Appeal Decision

Decision date: 01 April 2020

Appeal Ref: APP/C3810/W/19/3243339
54 Arundel Road, Littlehampton BN17 7DD

- The appeal is made under section 78 of the Town and Country Planning Act 1990 against a refusal to grant planning permission.
 - The appeal is made by C Houston of Haven Sent Properties Ltd against the decision of Arun District Council.
 - The application Ref LU/125/19/PL, dated 15 April 2019, was refused by notice dated 19 September 2019.
 - The development proposed is demolition of 3 no. garages and erection of 7 room HMO with shared facilities and parking for 3 cars.
-

GROUND FLOOR PLAN PROPOSED

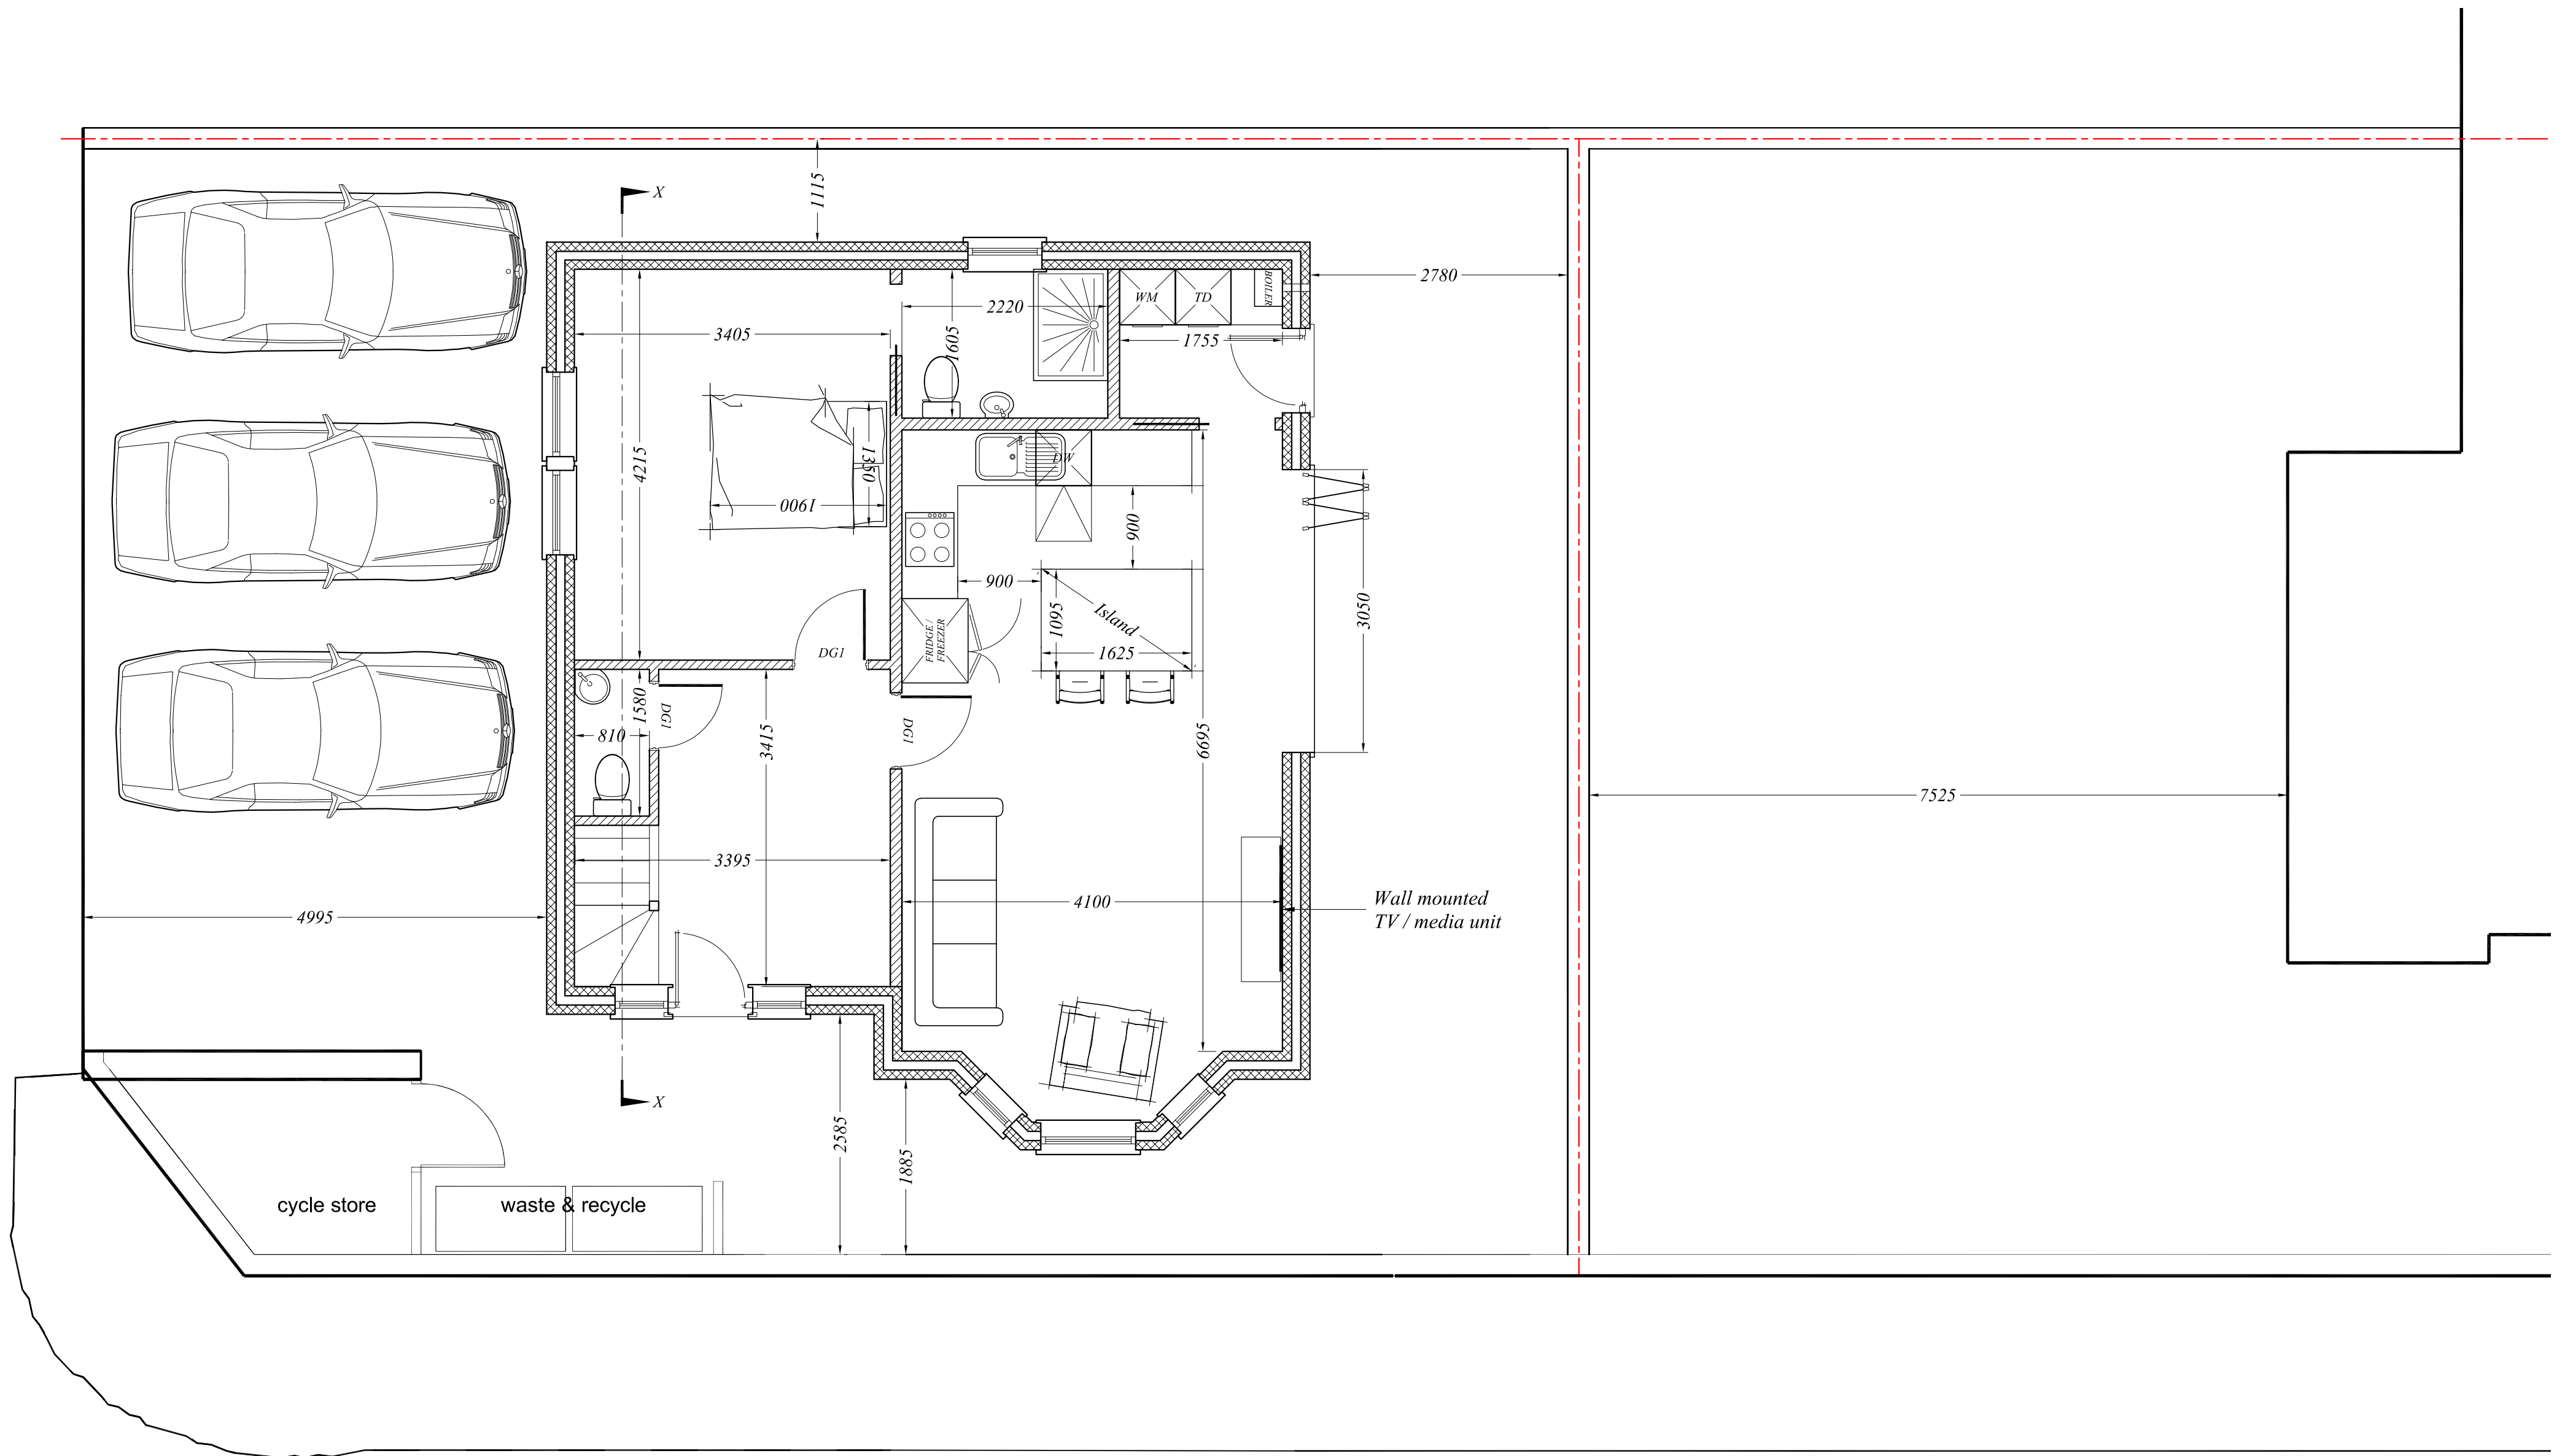
16. The ground floor window in the west elevation of the proposed building serving the kitchen/living room would face towards a tall boundary wall, which would be positioned approximately 1.0 metre away to demarcate the sub-division of the plot. Whilst the boundary wall would restrict the outlook from the kitchen/living room and the amount of natural light reaching it, the primary outlook from the kitchen/living room and source of natural light to it would be from a full-length window/patio door which would face the proposed courtyard garden. Therefore, the outlook from the kitchen/living room and level of natural light reaching it would not be so restricted as to be harmful to future occupiers.

17. However, the outlook from the window in the south elevation of the proposed building that would serve the ground floor bedroom would be towards the existing tall boundary wall which would be approximately 1.0 metre away. Consequently, the boundary wall would significantly diminish the outlook from the window and reduce the amount of natural light reaching it.

FIRST FLOOR PLAN PROPOSED

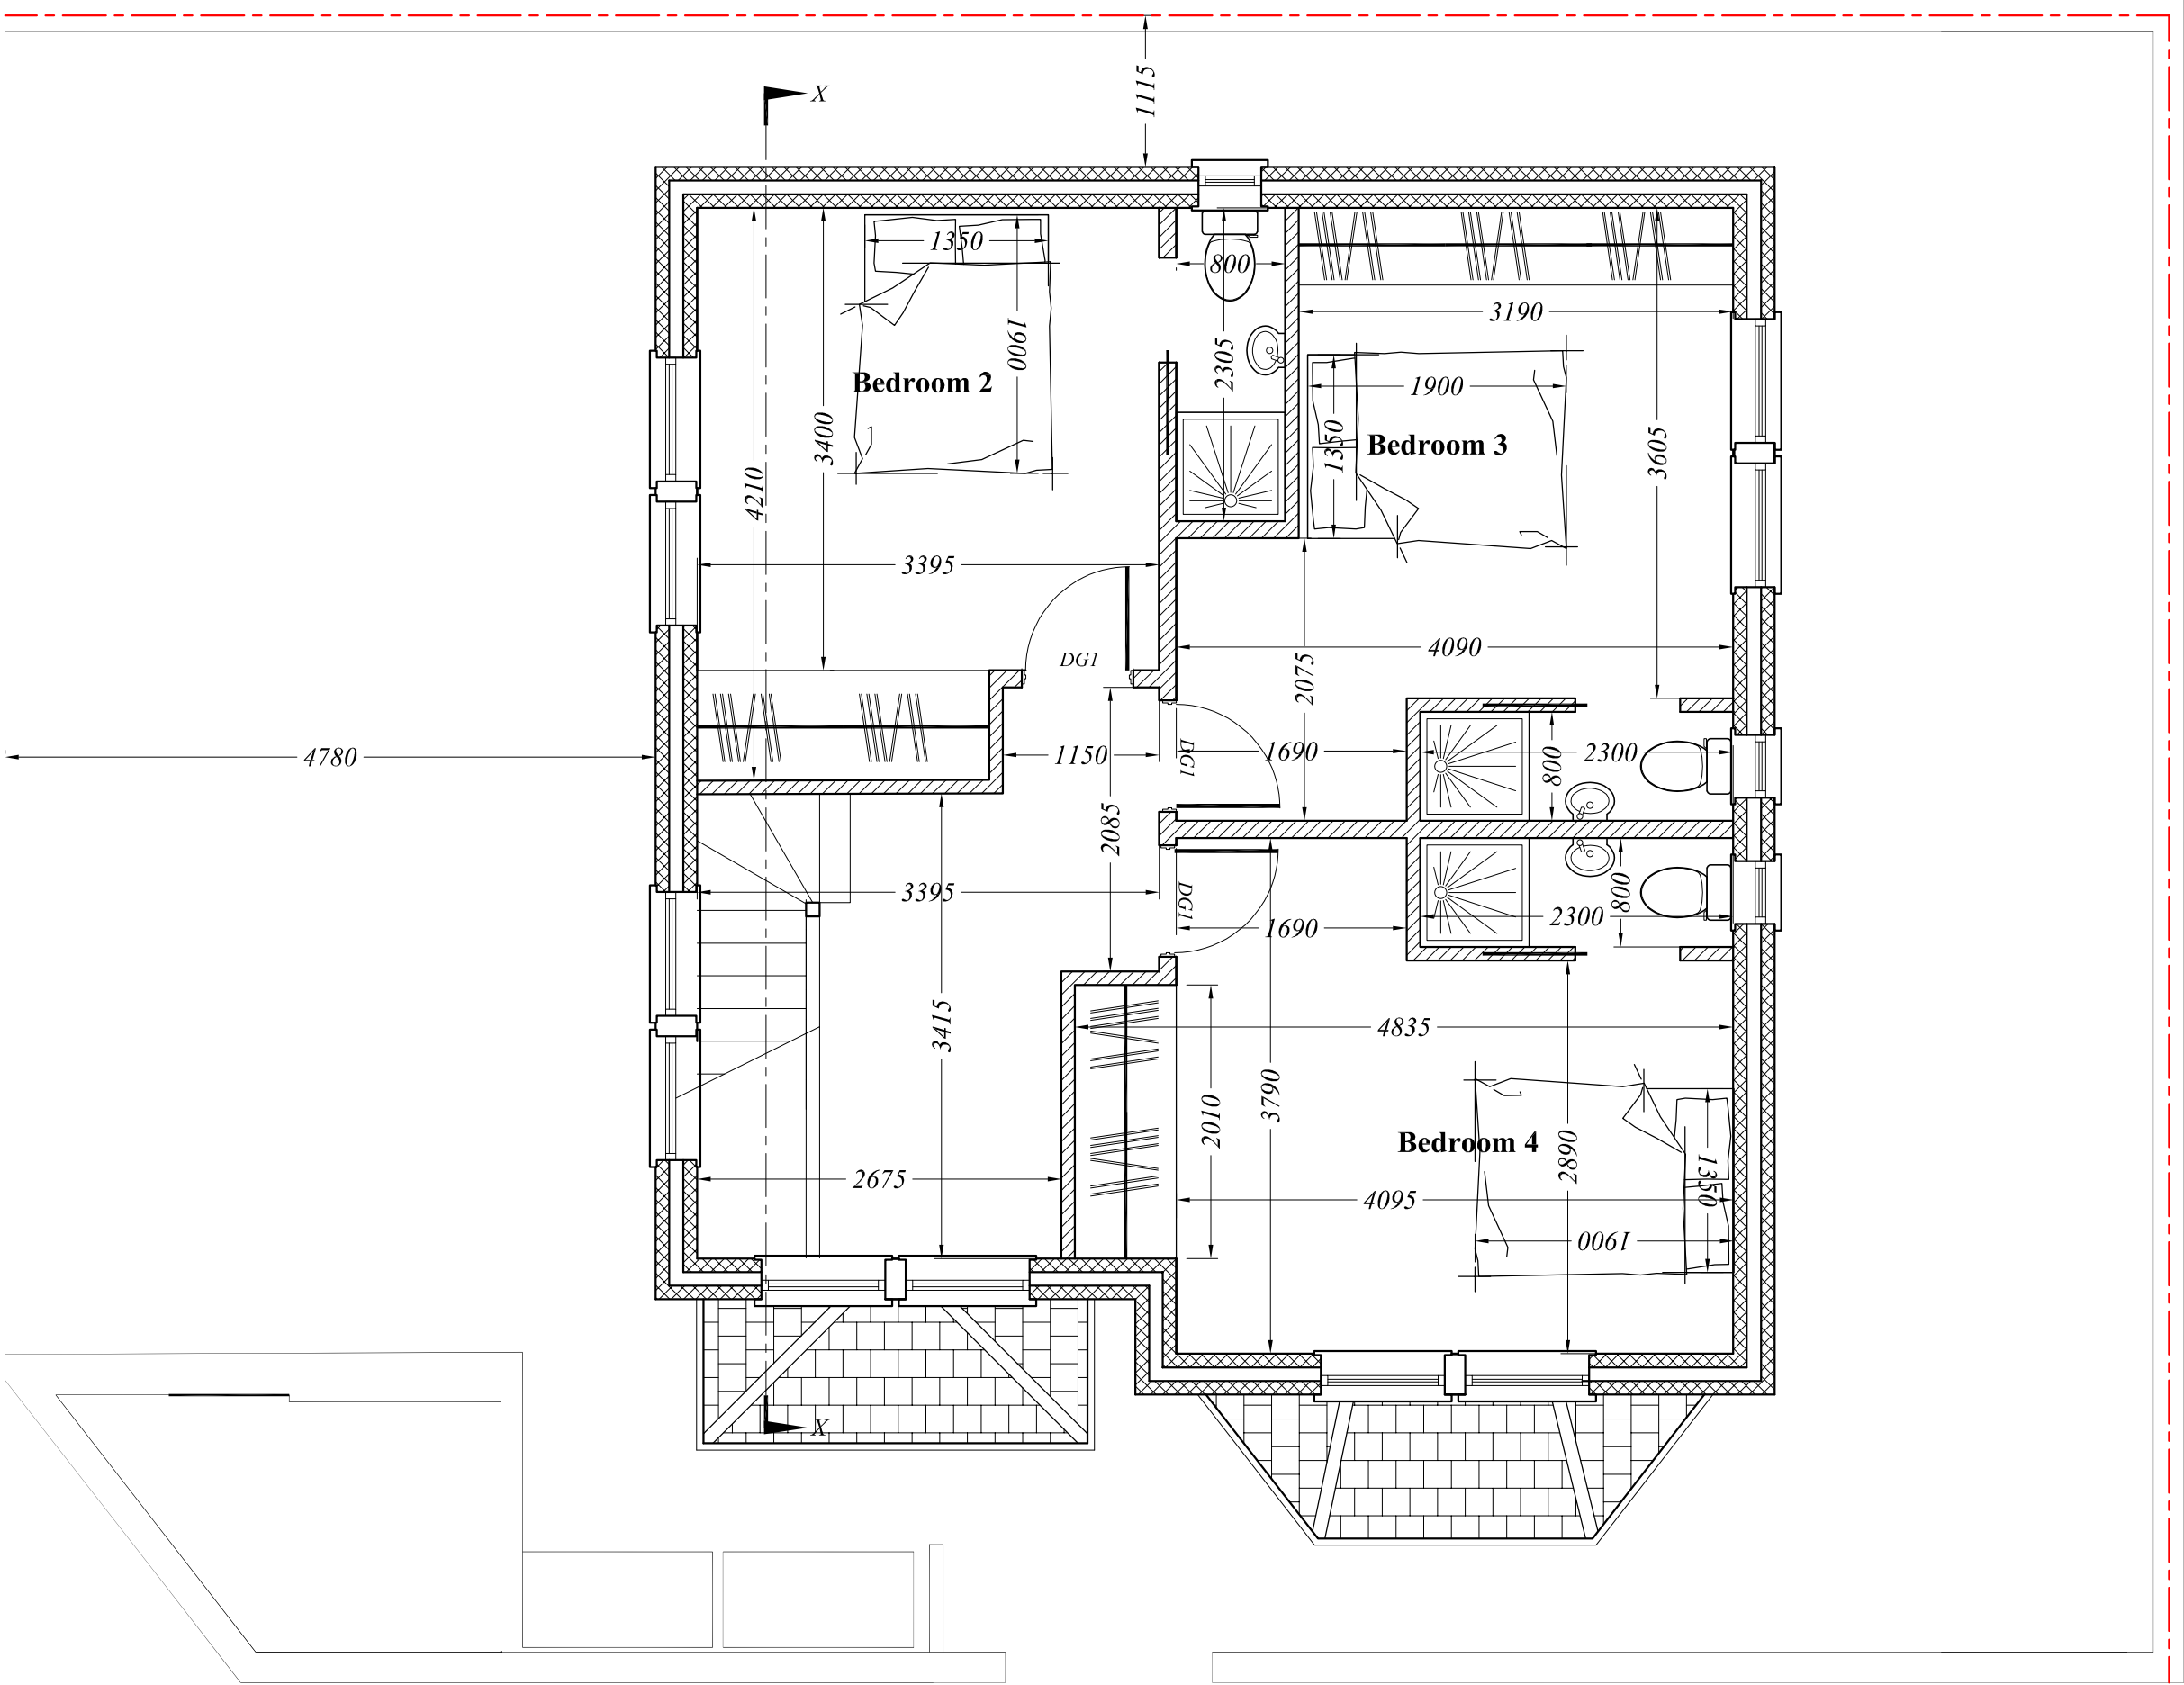
14. However, whilst two of the windows at first floor level serving habitable rooms would be at a high level, there would also be narrow full-length windows positioned within protruding bays in the east and west elevations of the proposed building. Given the position of the proposed full-length windows and the degree to which they would look towards the side elevation windows of No 1 and the rear elevation windows of Nos 52 and 54 and their respective rear gardens, the proposal would result in a significant loss of privacy to the occupiers of No 1 and Nos 52 and 54 due to overlooking.

18. At first floor level, two of the bedrooms would be served by high level windows and narrow full-length windows positioned within protruding bays. These would provide natural light and some views, albeit mainly of the sky in the case of the high level windows. Whilst more restricted than full size windows, the outlook from the windows and the level of natural light reaching them would not be so restricted as to be harmful to future occupiers.
